# CITY OF ALBUQUERQUE

May 31, 2016

**Re: McDonald's at San Mateo and Academy  
Request for Permanent C.O. - Accepted  
Engineer's Stamp Date 2-9-16 (E18D019C)  
Certification date: 5-27-16**

Drawing file: E18D019C / C7.0 GRADING PLAN.pdf

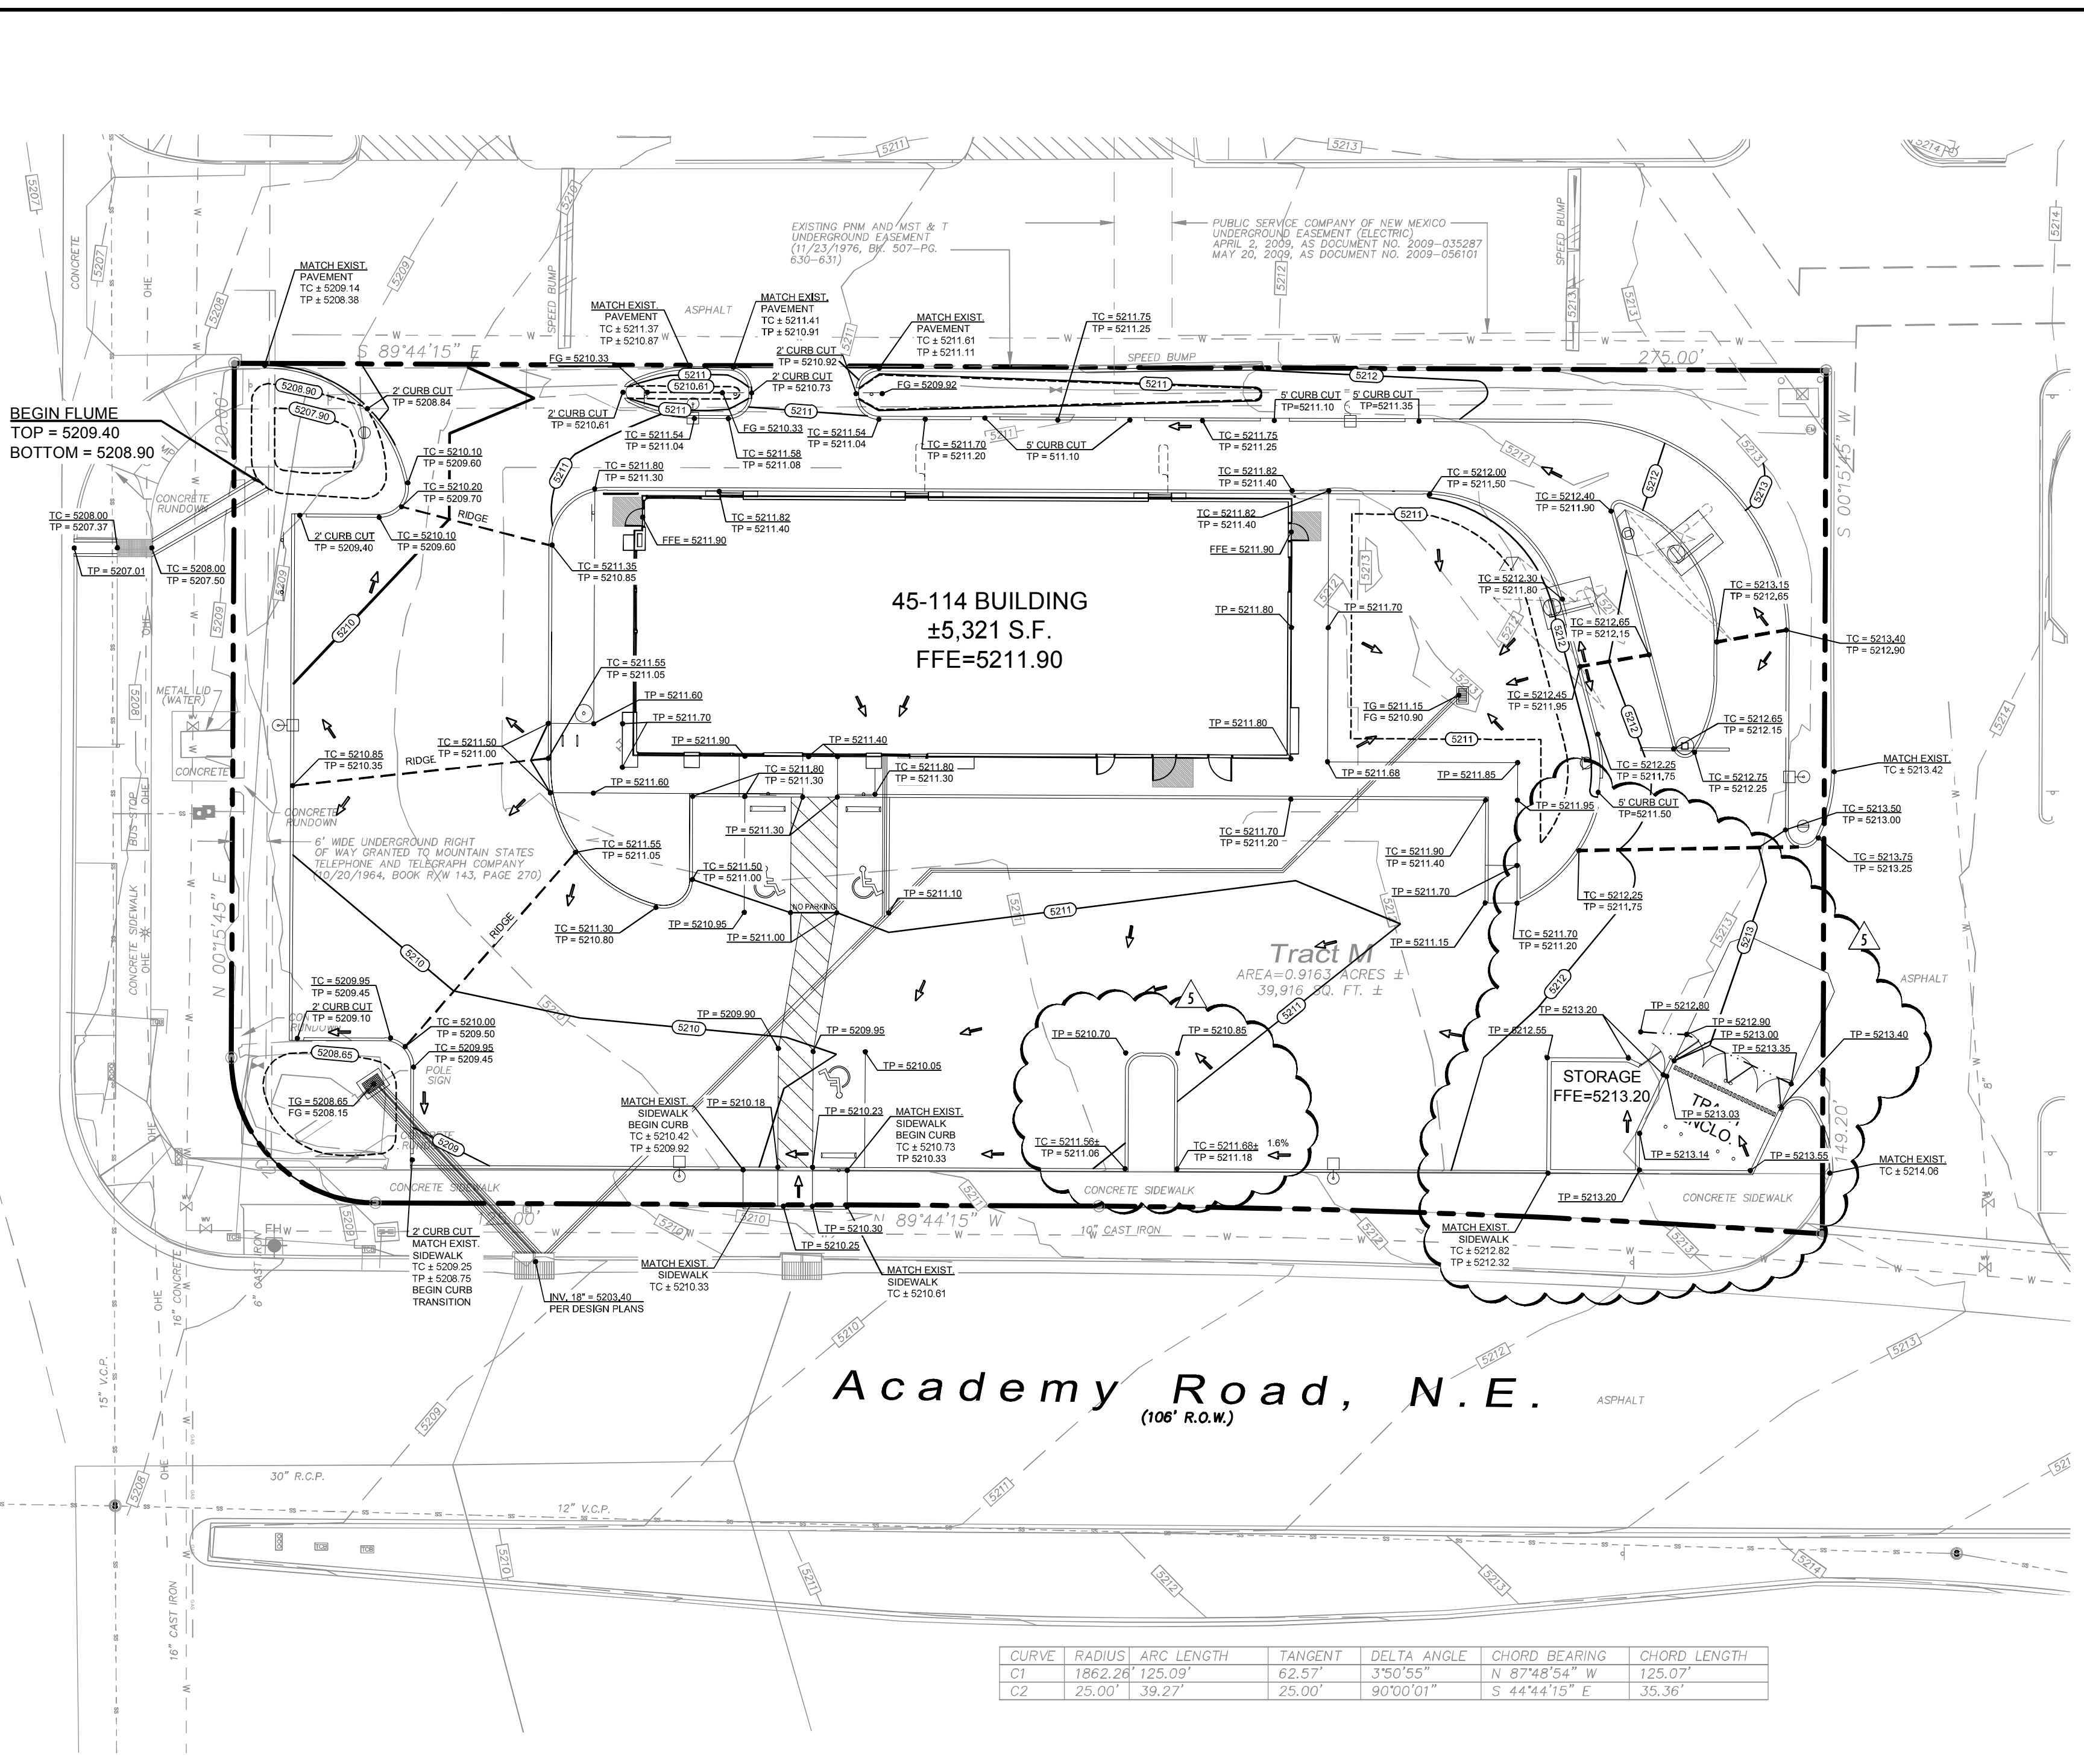
1. The swale on the NW corner was not constructed per the approved plan. Water must not drain into the right-of-way. Attached is a copy of an option on how to address the flows.

create small  
drop down  
area or swale  
to convey to  
sw culvert
